Lead Local Flood Authority – Statutory Consultation

Consultation on Application Number: 2018/90491

Address: Discharge of condition 3 (materials), 4 (drainage scheme), 5 (drainage scheme), 8 (highway works), 10 (estate roads), 11 (cycle storage), 12 (Phase 1 Report), 17 (method statement) and 19 (bat survey) on previous permission 2014/93584 for demolition of dwelling and erection of 10 dwellings

Proposal: 120, Laund Road, Salendine Nook, Huddersfield, HD3 3TY

DRAINAGE PLAN & DETAILS

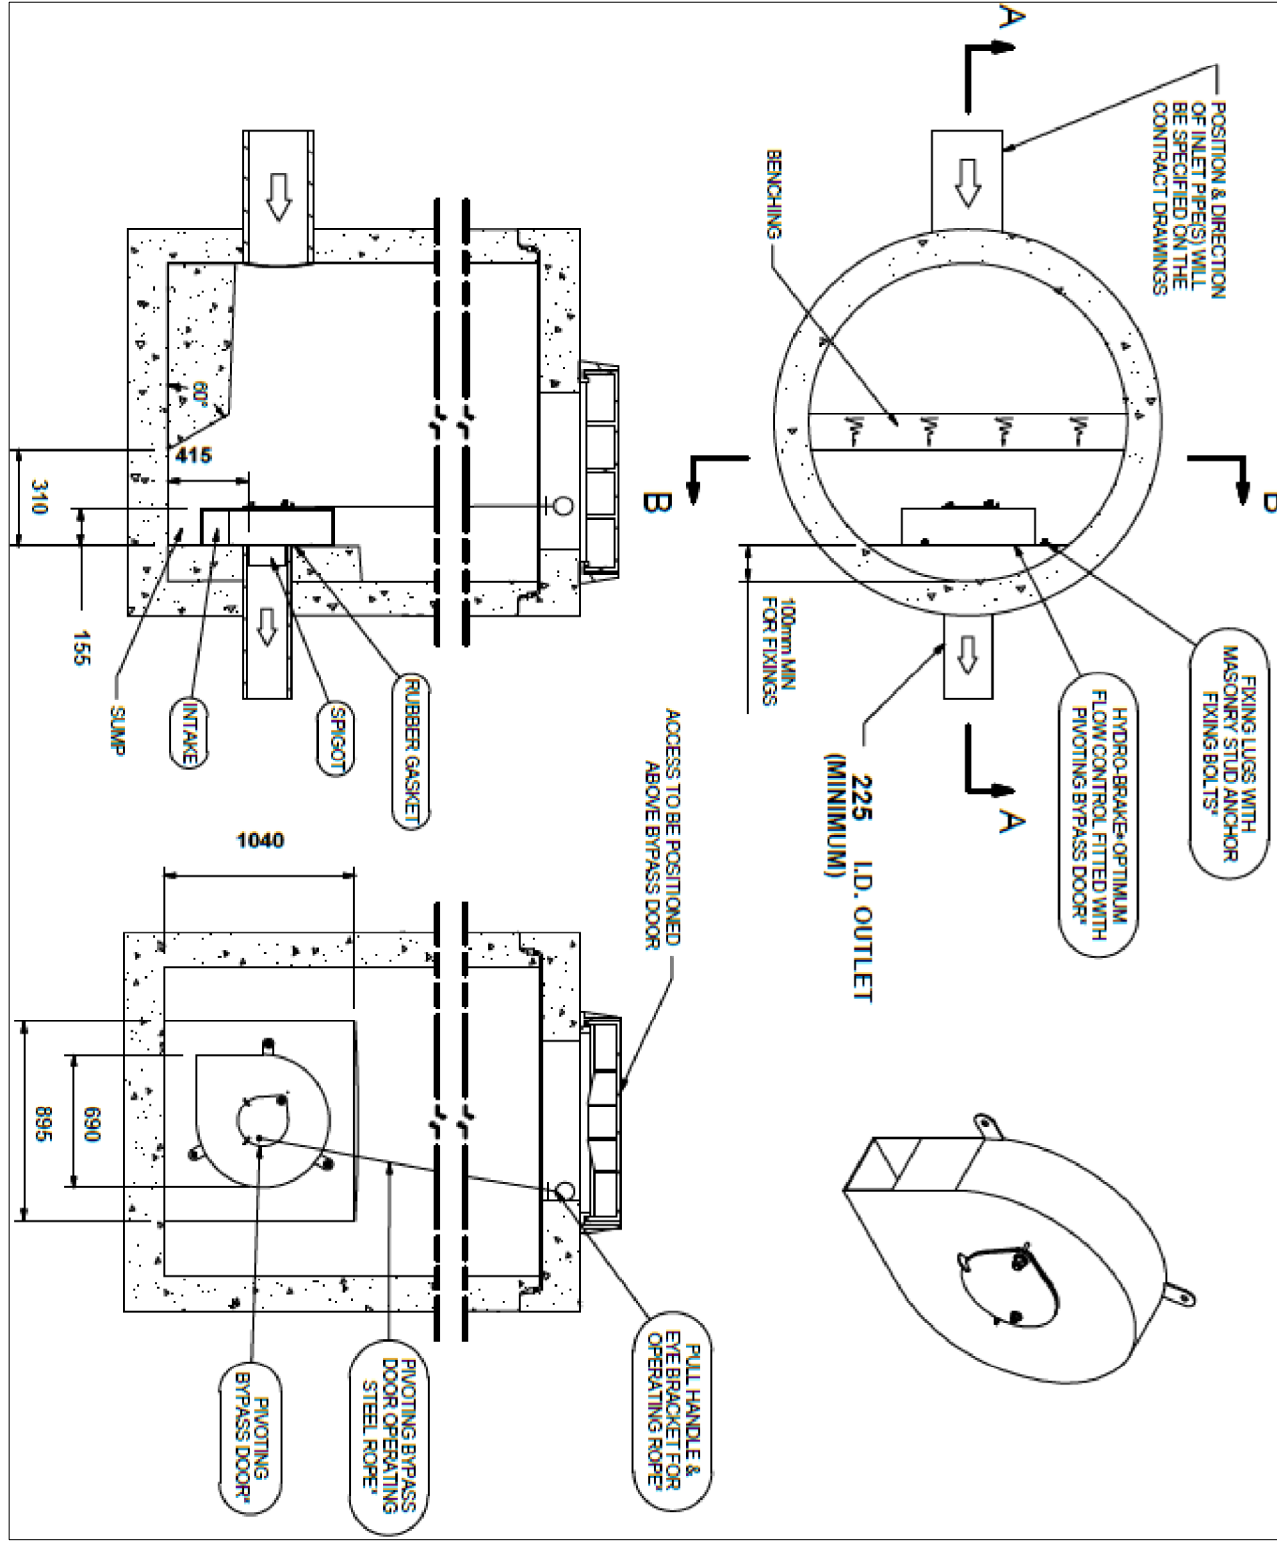
The design far exceeds the 3l/s limit imposed as a condition and therefore conditions 4 and 5 should not be discharged.

An attempt has been made to dictate a discharge rate that is not recognised by the LLFA, it also fails to take into account DEFRA guide to volume control which cannot be achieved so is offset by limiting to a 1 in 1 year return rate less 30% for the connected positively drained areas only. A minimum of 3l/s was imposed that reflects the lowest reasonably practicable discharge rate to achieve a 75mm orifice with current designs of flow control available.

For future revisions a microdrainage simulation of an acceptable design with an acceptable discharge rate must be submitted.

Early dialogue should be made with the LLFA and Yorkshire Water in this instance as it increases the risk of flooding in the public sewer network and is contrary to local and national guides.

We do NOT recommend that these conditions are discharged.
